**Re: Hornsby Ku-ring-gai Hospital - Redevelopment Stage 1
Property: Corner of Burdett Street and Derby Road, Hornsby**

Thank you for your letter dated 11 January, 2013 regarding the above matter. Council has reviewed the documentation and plans submitted as part of the application for the Stage 1 re-development of the Hornsby Ku-ring-gai Hospital and provides the following comments:

Appendix 1

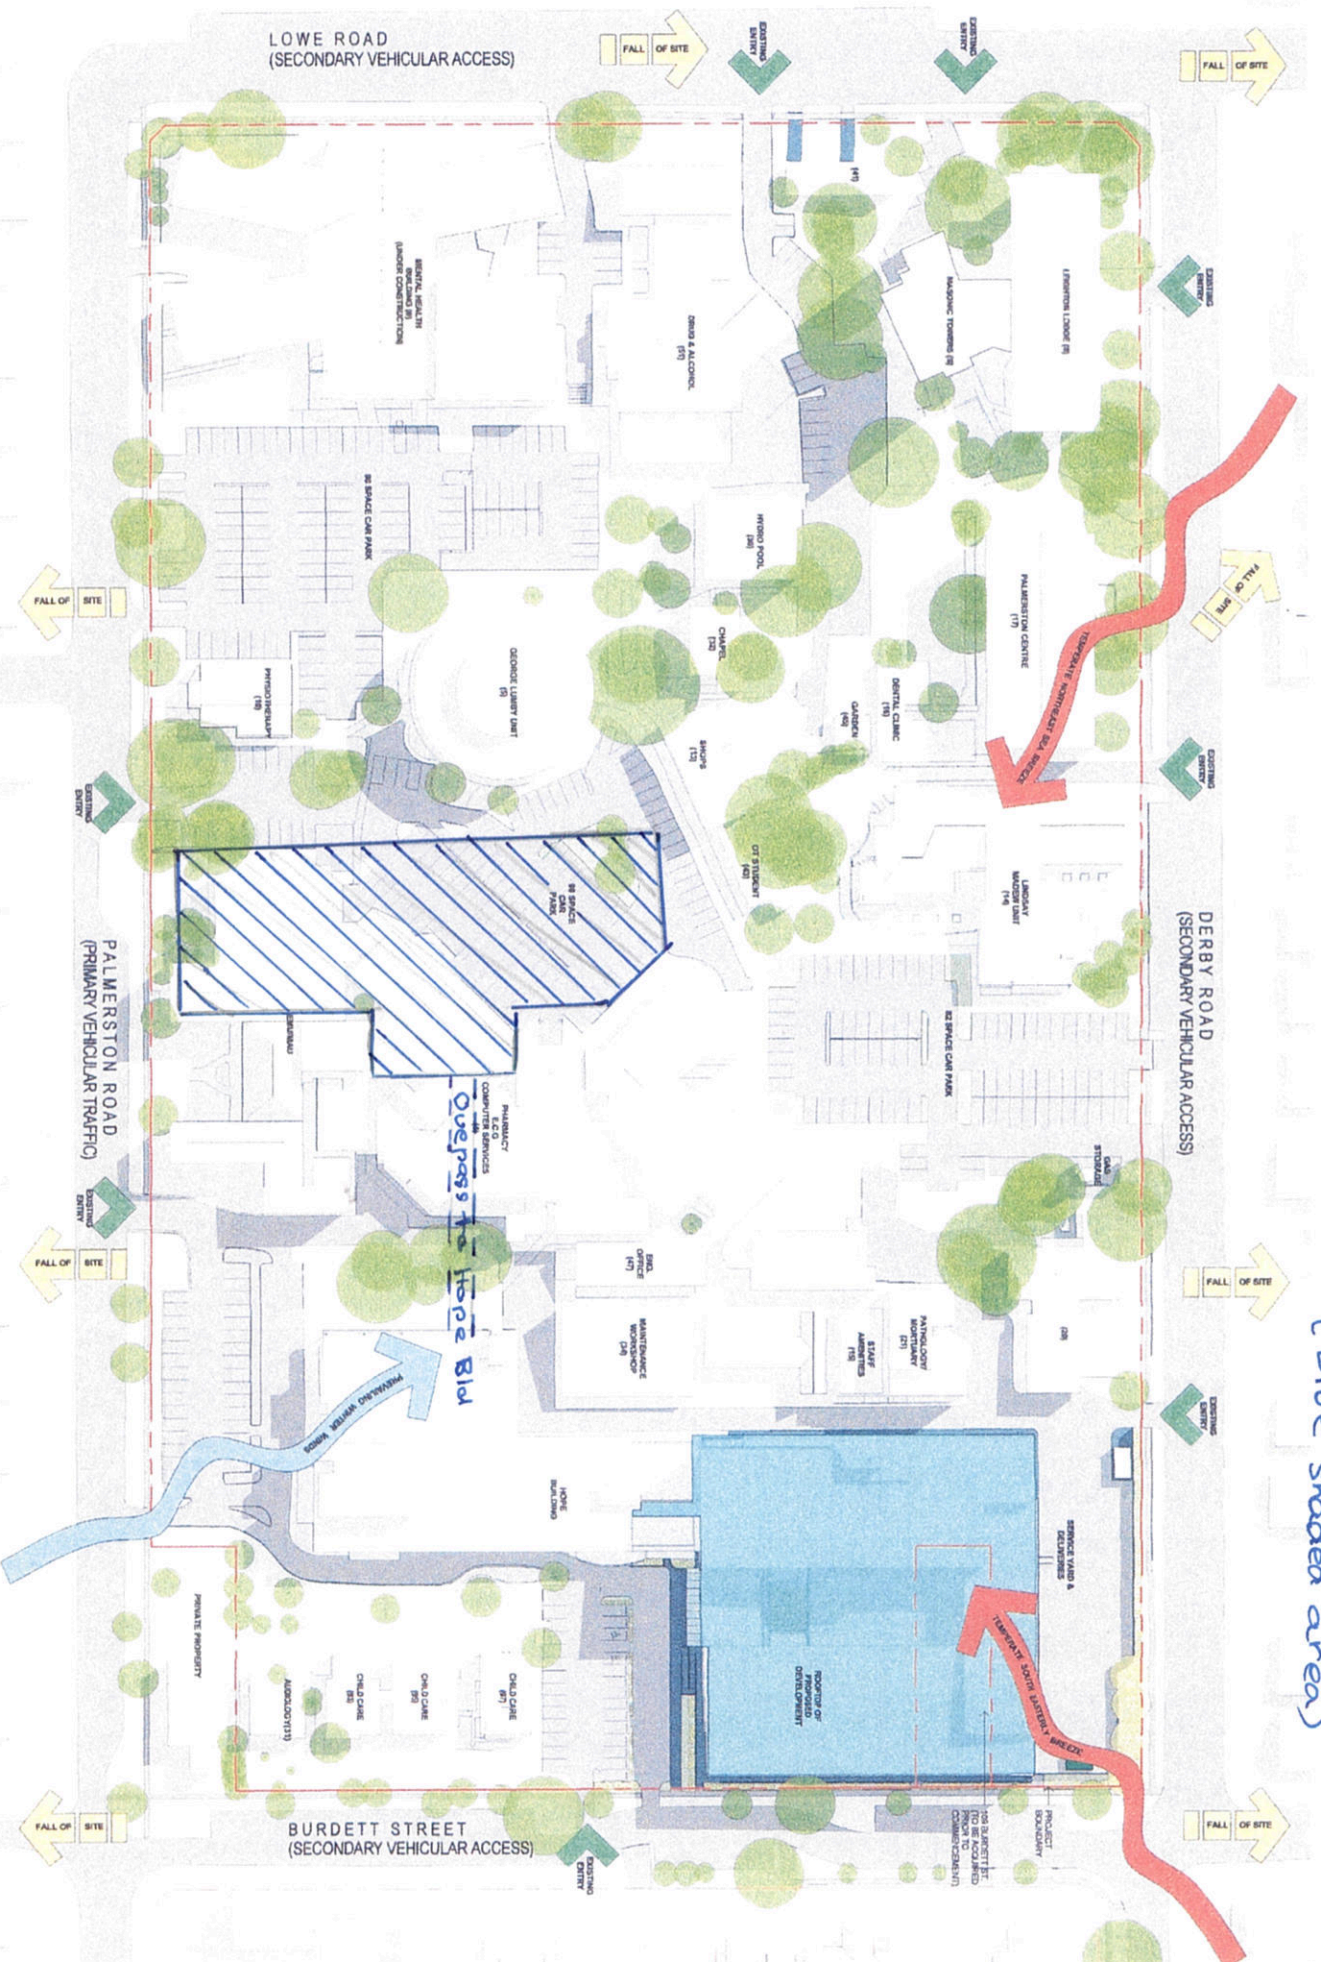
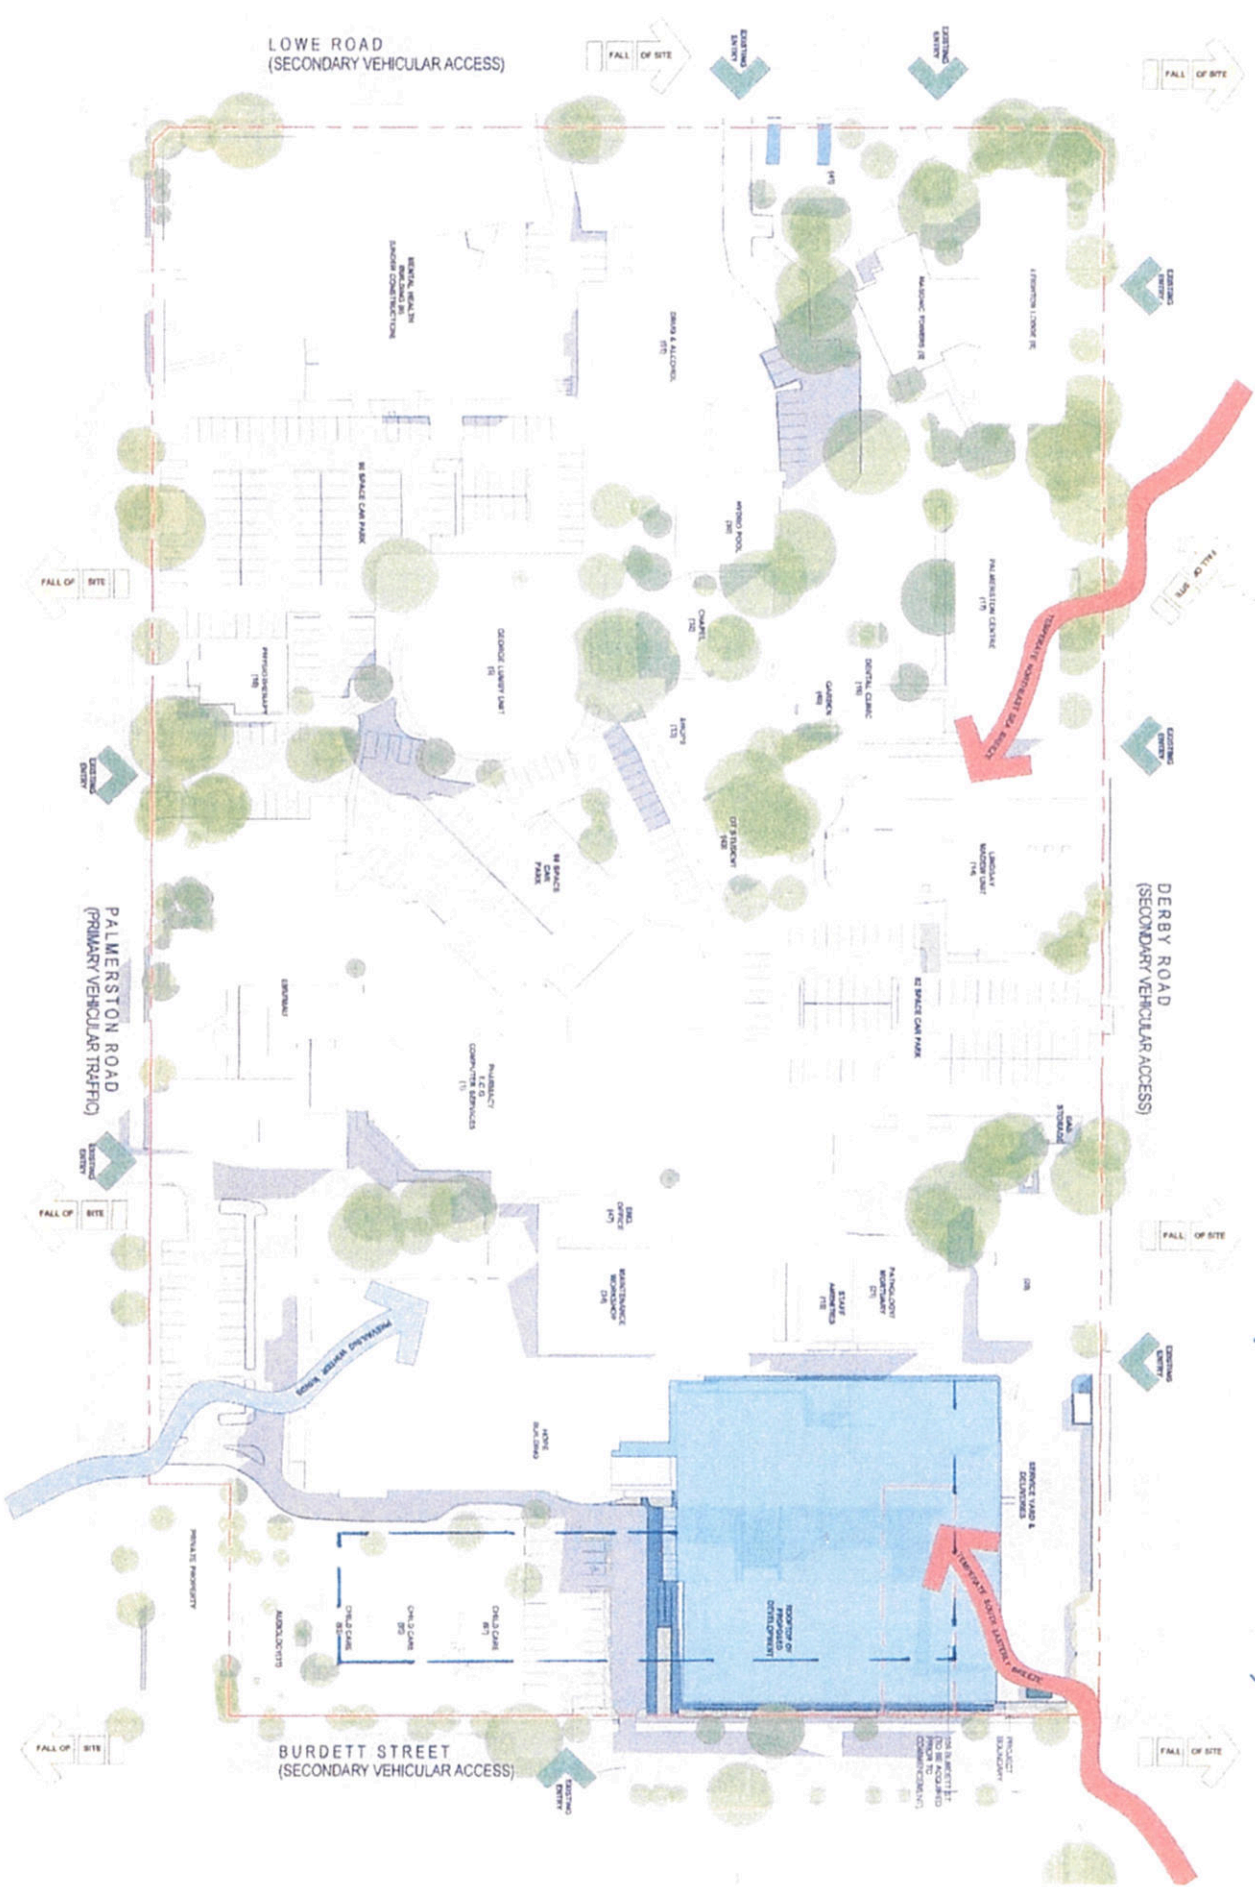
Council recommends that the building setback to Burdett should be increased to enable additional landscaping within the site between the building and the property boundary along this frontage. Typically Burdett has building setbacks of 6 - 7.6 metres while the proposed building has minimal setback of 1.5m and a height of approximately 11m. There is limited articulation of the building facade. The setback should be more consistent with the existing established streetscape. Small trees should be provided in the additional landscape area between building and property boundary to reduce the visual impact of the building on the streetscape.
